From: Simon Davis
Sent: 06 March 2020 17:25
To: Ben Daines [REDACTED]
Subject: RE: BE/137/19/RES The Cottage, Shripney Road

6.06 Plot 17-20

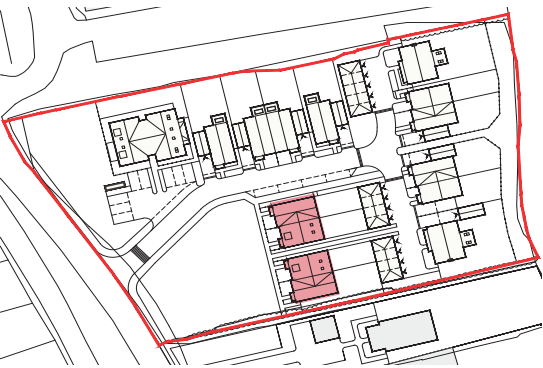
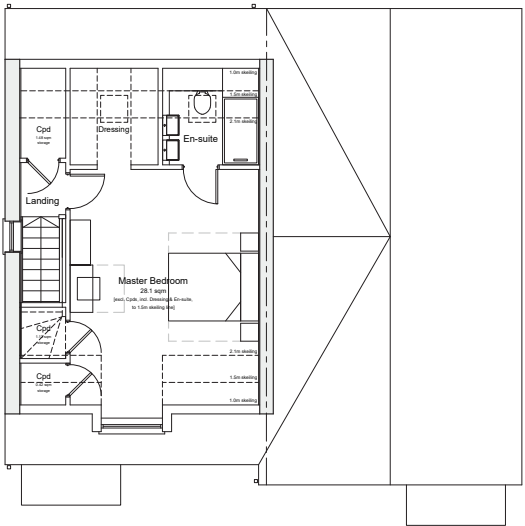
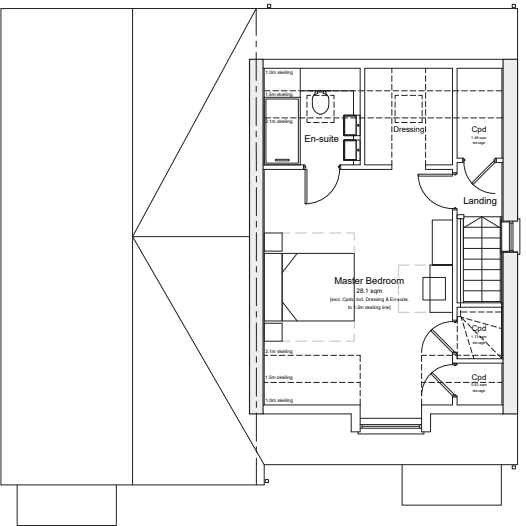
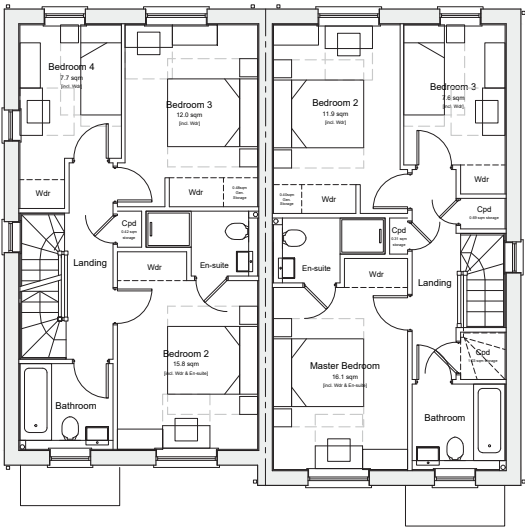
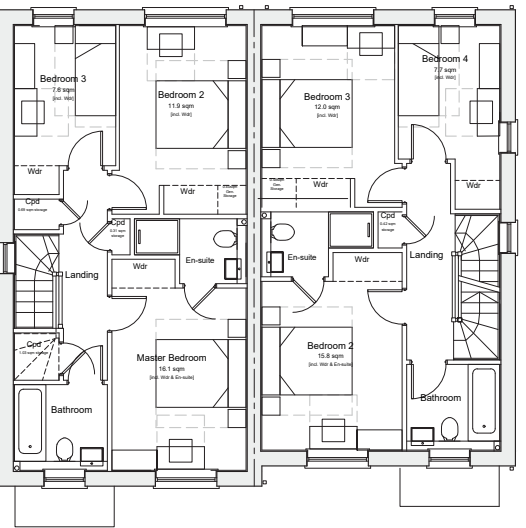
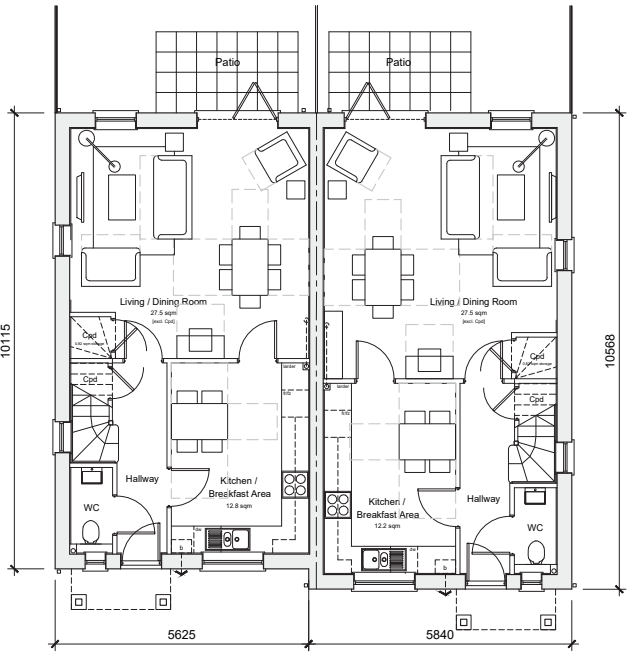
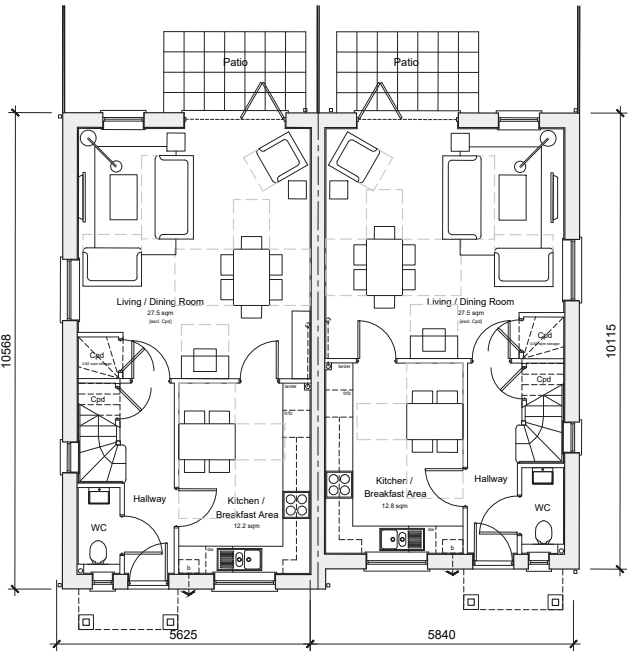
Please also note that there were concerns with how the parking will work with plots 17-20 given that the on-street visitor spaces are closer to their front doors. Also that plots 11 & 14-16 are facing onto car pots are not great from an amenity perspective. It was suggested that you could turn units 17-20 by 90 degrees to face the new road. We would not refuse due to these concerns but you may want to consider. We may however have to refuse due to the other concerns if you cannot resolve these. Happy to speak by phone next week.
